Portishead Branch Line (MetroWest Phase 1)

9.29 ExA.CAS.D4.V1 – Applicant's response to Additional Submission of Mr Stuart Tarr (AS-053)

THE PORTISHEAD BRANCH LINE (METROWEST PHASE 1) ORDER
Applicant's Responses to Mr Tarr's Representations Submitted for ISH 2 and 3 (AS-053)

Drawing file path & name: \\Projects\467470 NSC Framework\2019\BQ.04.20 MW Phase 1 Highway Engineering\BQ.04.20-224 Rev E.dwg

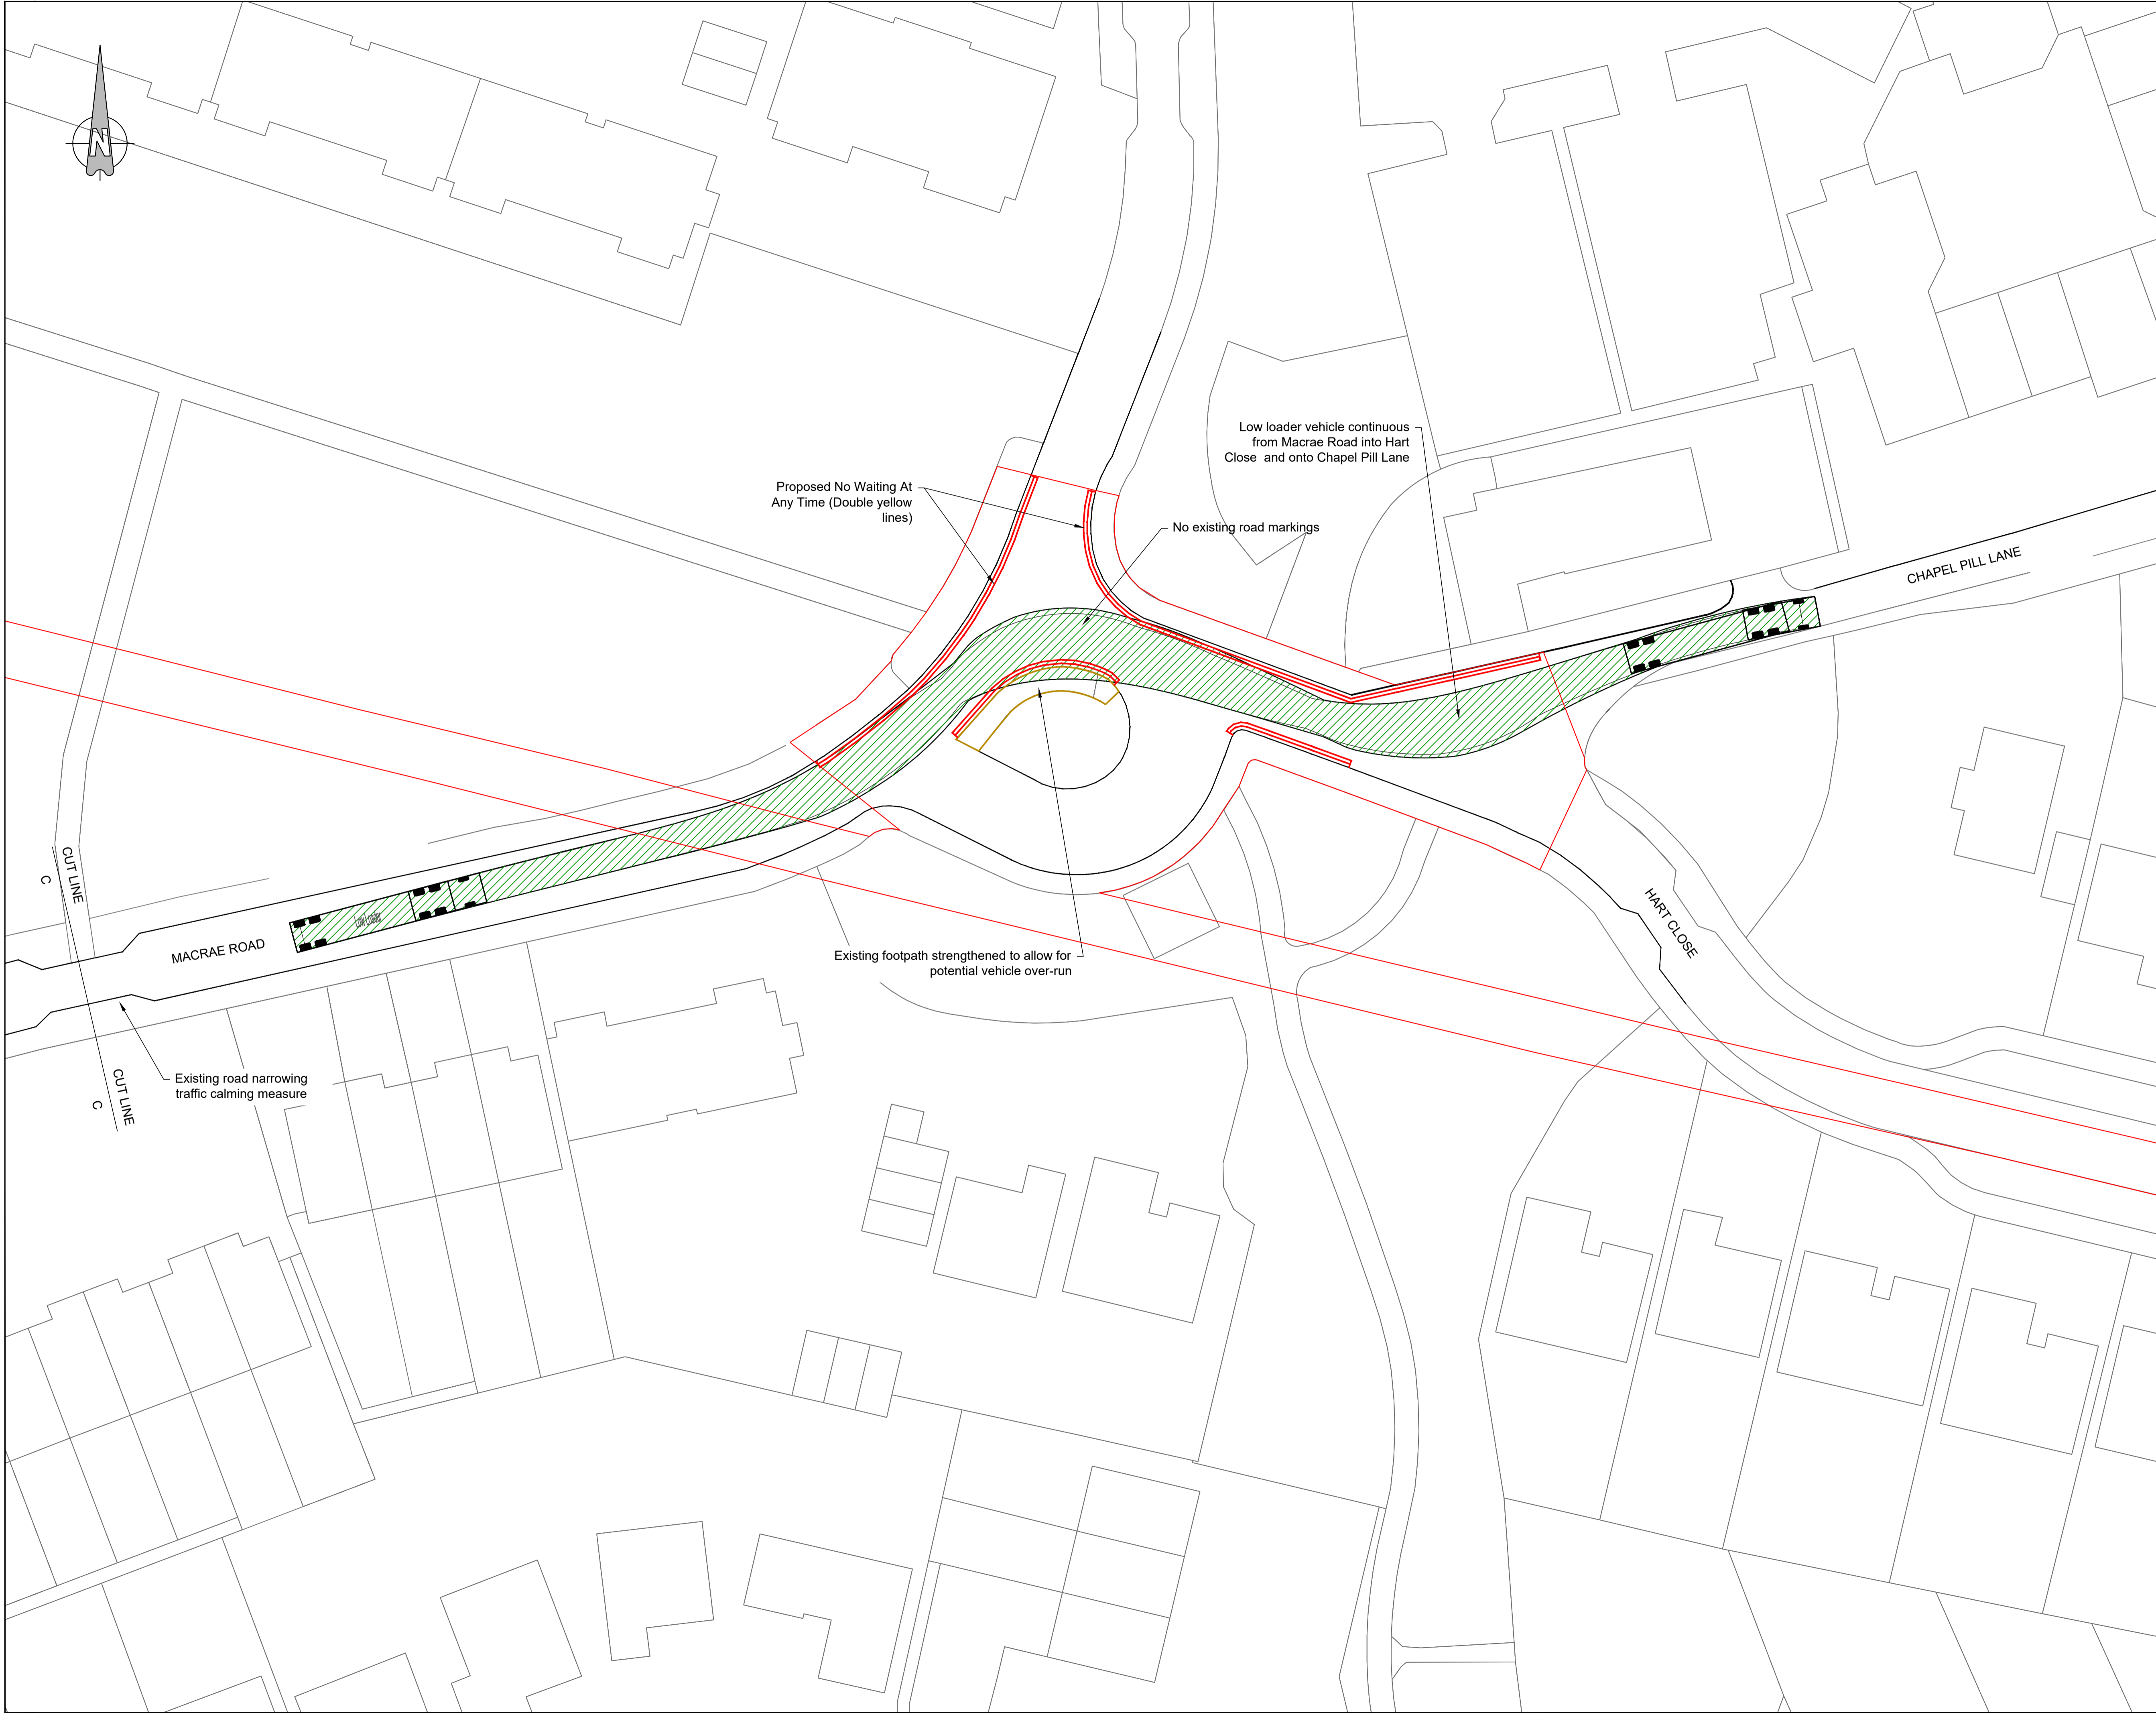
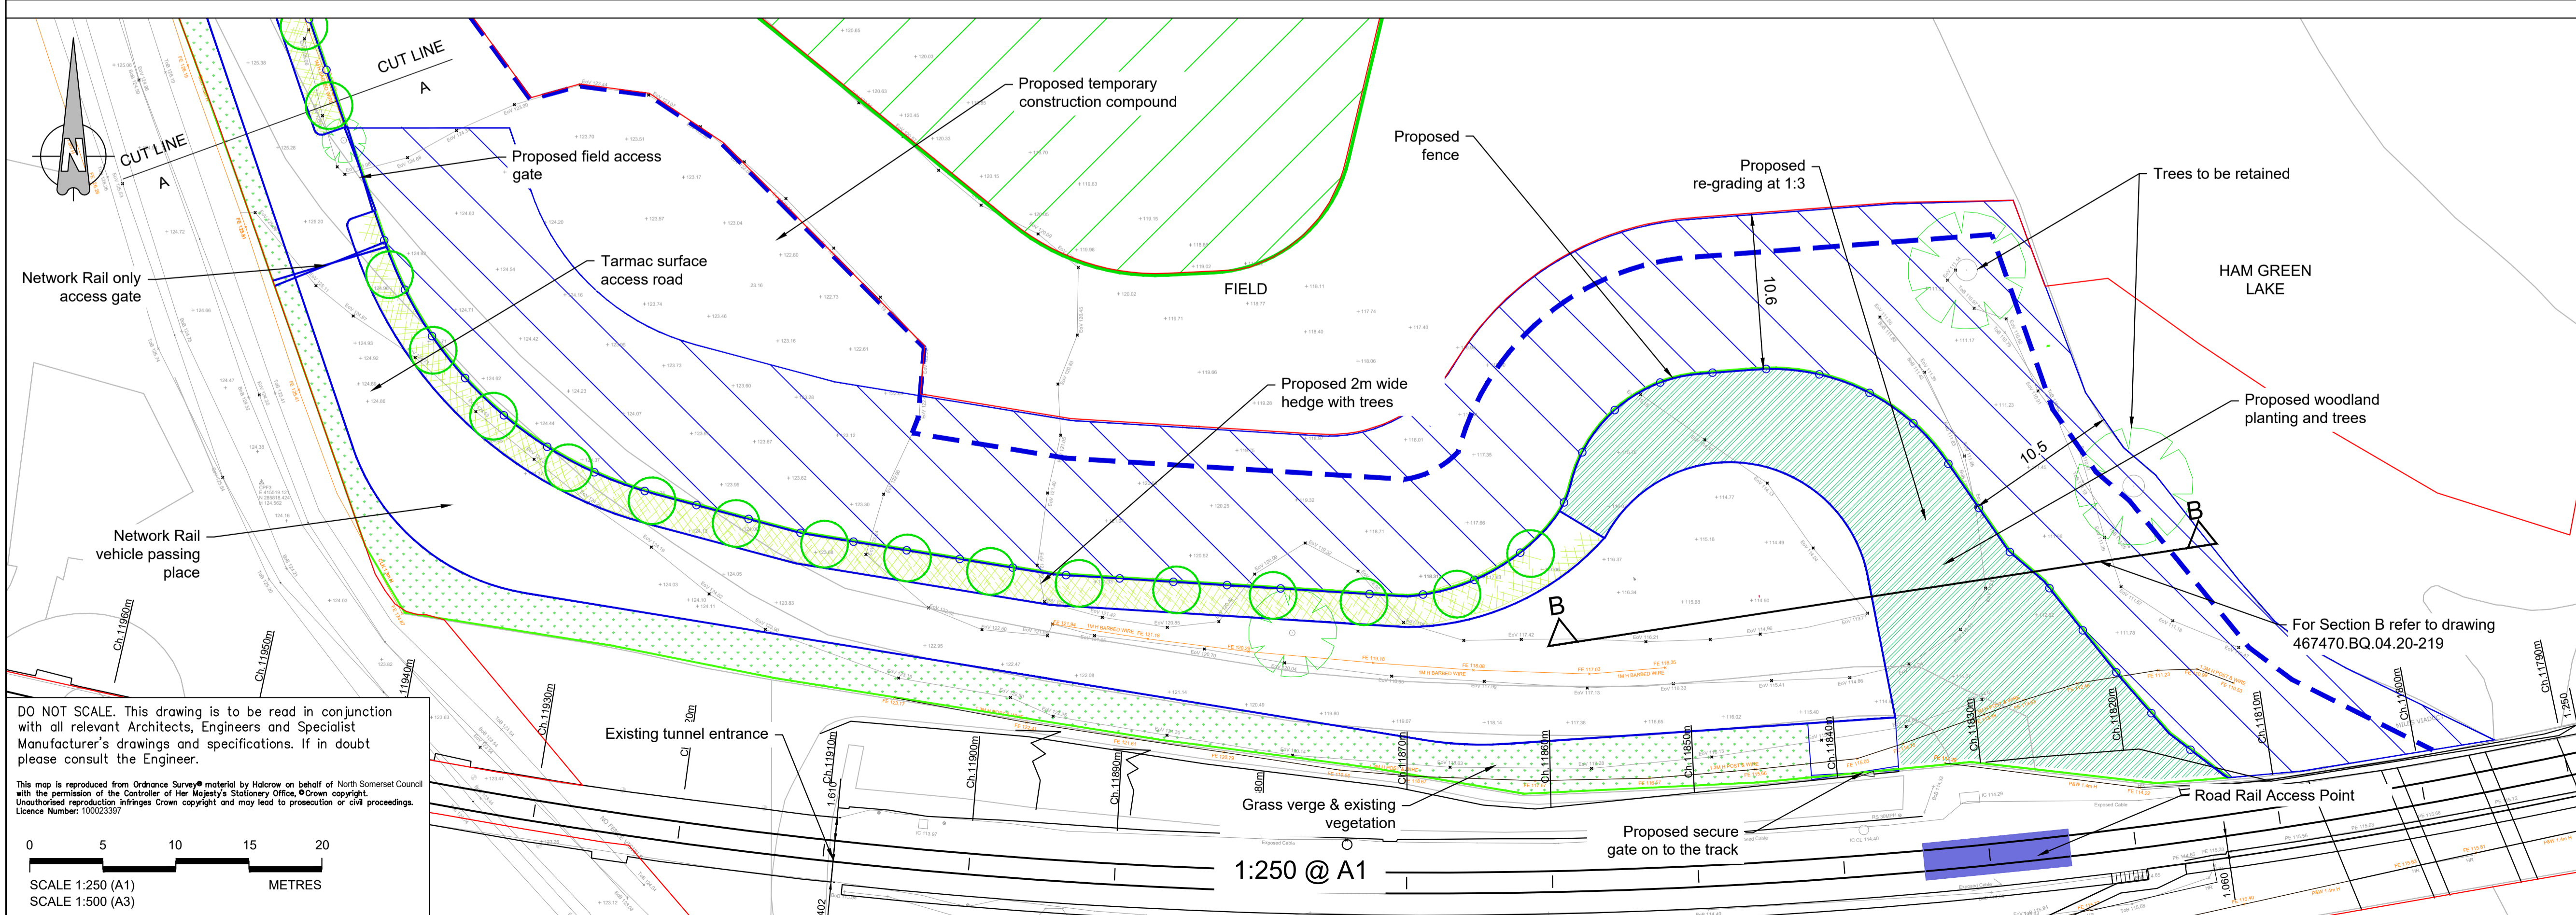
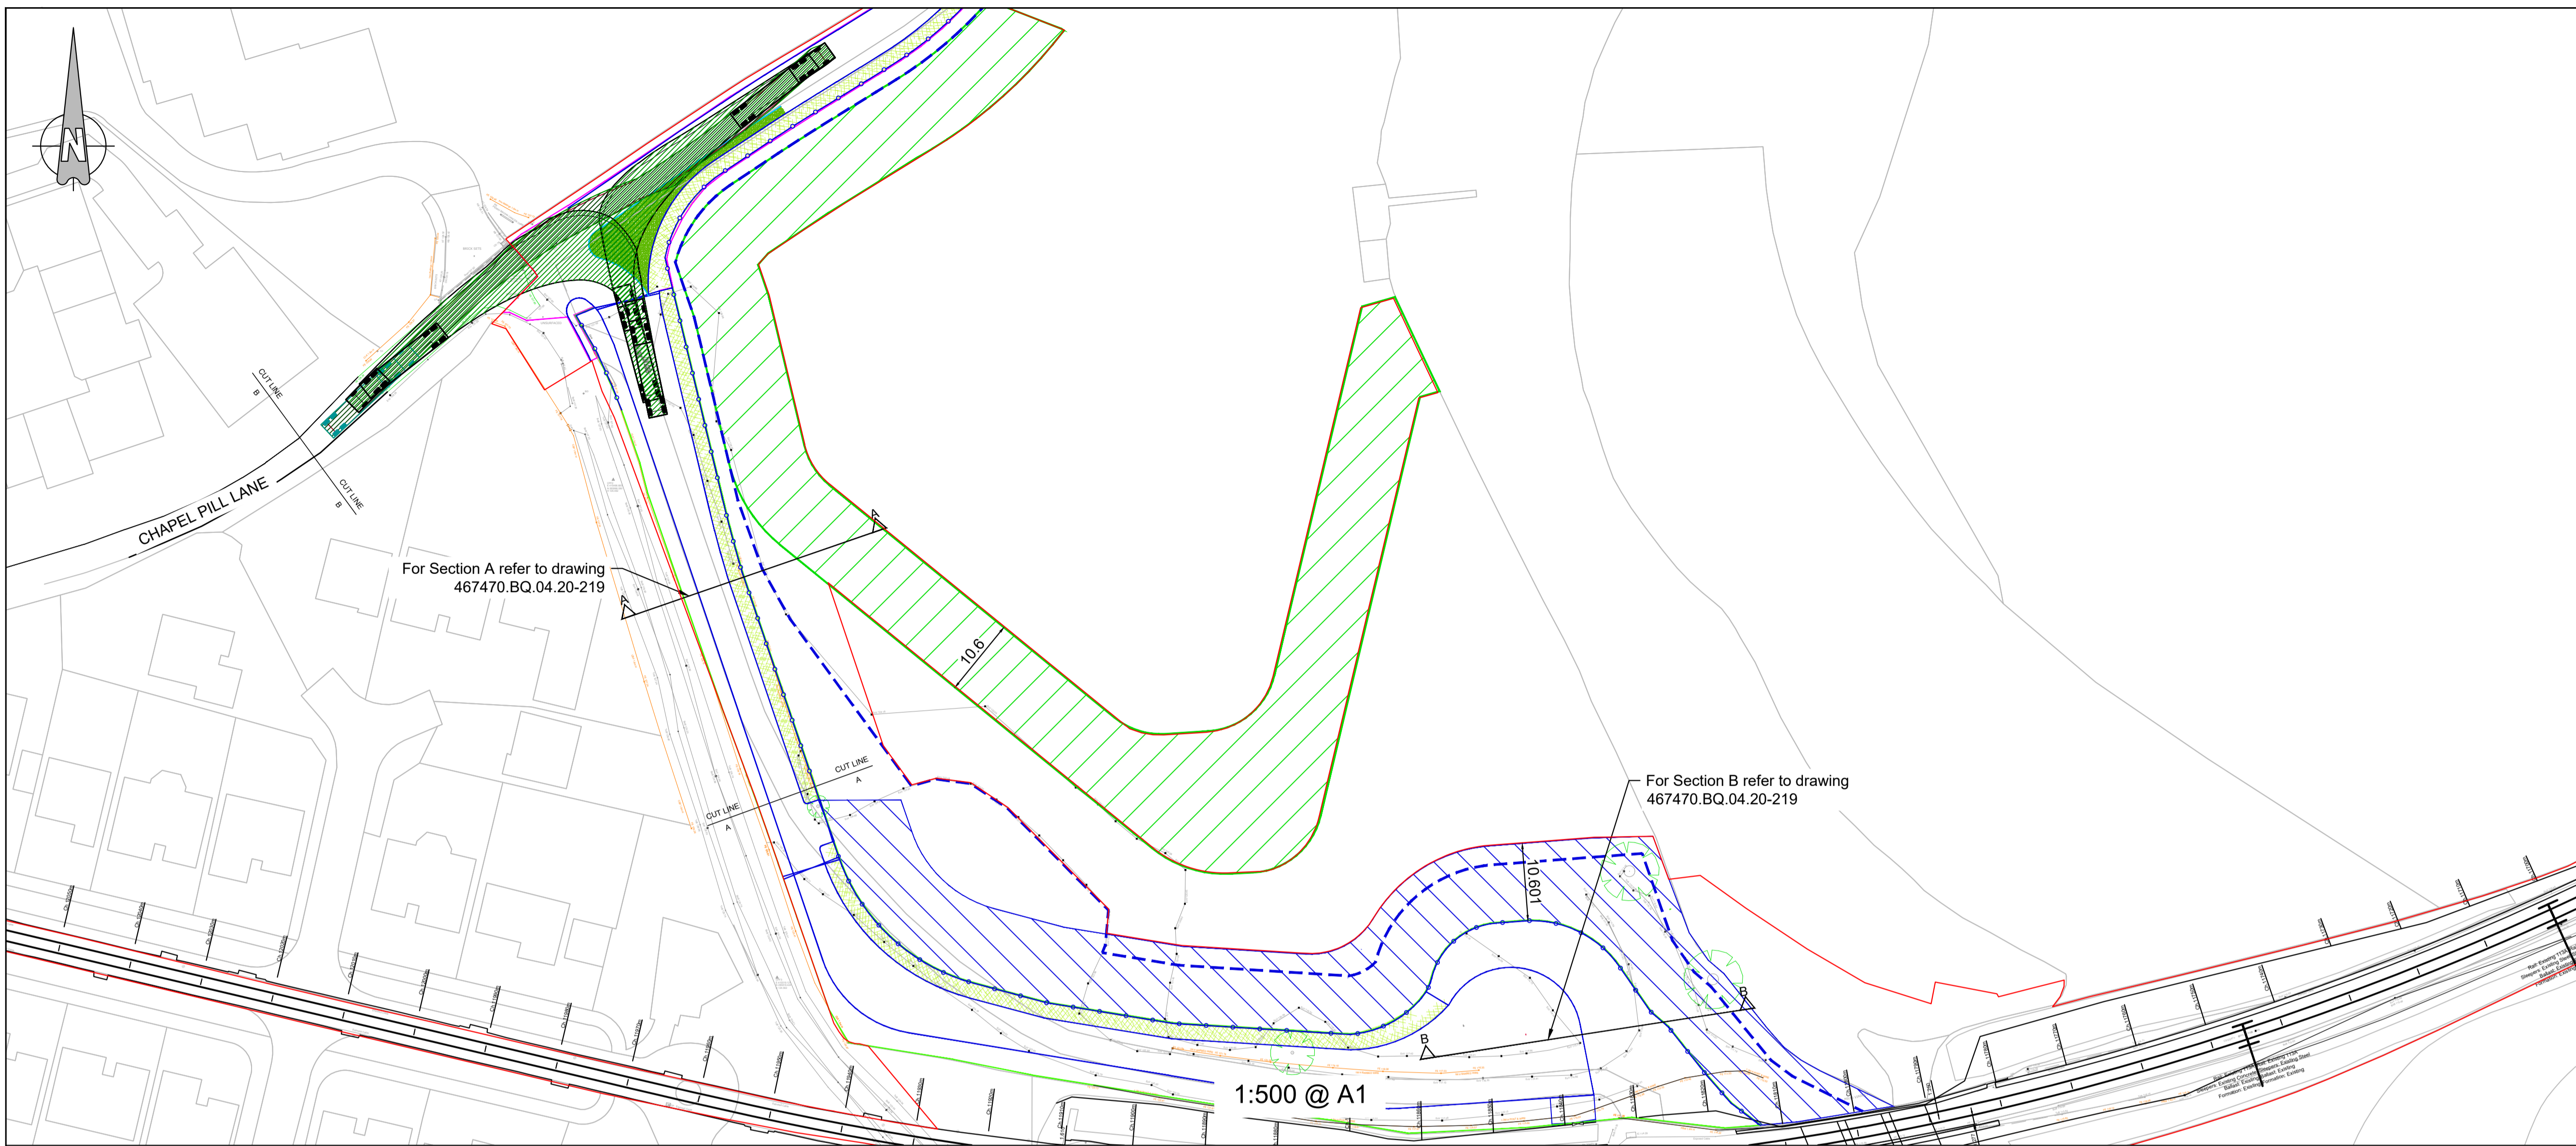
10.	<p>Hearing 2: Construction Practices and Related Matters</p> <p>3.1 Grasscrete is being used for the junction at Chapel Pill Lane so why can this not be used for the track/access road? Why does the access need to be a permanent road surface, especially as</p>	<p>3.1 The area of 'grasscrete' (used here as a generic term to describe a reinforced grass surface that allows vehicles to track over the surface) at the junction is to allow for a low loader vehicle to manoeuvre onto the access track to the compound whilst maintaining the appearance of a grass verge. See APP-040 / 2.45 - 2.46 - Ham Green Highway Works Plans and Pill Tunnel Eastern</p>

Ref.	Mr Tarr's Question	Applicant's response
	<p>the previous access track since dismantled was able to accommodate heavy goods vehicle (HGV) movements with a temporary surface for the repair and upgrade works to the Pill Tunnel when re-establishing the rail freight line? Moreover, this would result in a more sustainable solution to protecting the openness of the Green Belt, its visual amenity, and protecting the bio-diversity of lake?</p> <p>3.2 Secondly, how often will the track be used for essential maintenance and drainage at the Pill Tunnel, for track inspections etc, and what vehicles will be required? Presumably, if there are frequent HGV movements, it would be inappropriate on highways and pedestrian safety grounds and would conflict with Network Rail's own safety regulations to share the access with the proposed social housing development referenced in the Neighbourhood Plan and which, for that reason, should be refused (see also the Applicant's response to Representations at the Open Floor Hearing Held on 19 October 2020)?</p>	<p>Portal Compound, Landscaping and Access Plan Drawing 467470.BQ.04.20-221, which shows the manoeuvre being catered for.</p> <p>'Grasscrete' is not considered appropriate on the access track as the track is also required for emergency access to the tunnel portal. Owing to the relatively steep slopes, a tarmac surface finish is considered appropriate to ensure vehicles do not skid on a grassed surface.</p> <p>The width of the access track has been minimised to 'single' lane with a passing place, and screened with a 2m wide hedge and trees.</p> <p>The temporary construction compound in this location is primarily to enable the construction of the access itself.</p> <p>3.2 Usage will be for inspection maintenance and emergencies. There will be visual track inspections and checking of the silt buster and pump for Pill Tunnel. These inspections could be weekly and 2-3 vehicles could be expected. Maintenance access will mainly be by vans or pickups. Larger vans/small trucks will only be required when works are planned that require RRV's or materials. Larger vans/small trucks should be expected circa two or three times a year.</p> <p>The adequacy of access for the housing development will be for the LPA to consider at the appropriate time. The Applicant for this Order is not in a position to comment on the proposals for access for that proposal.</p>
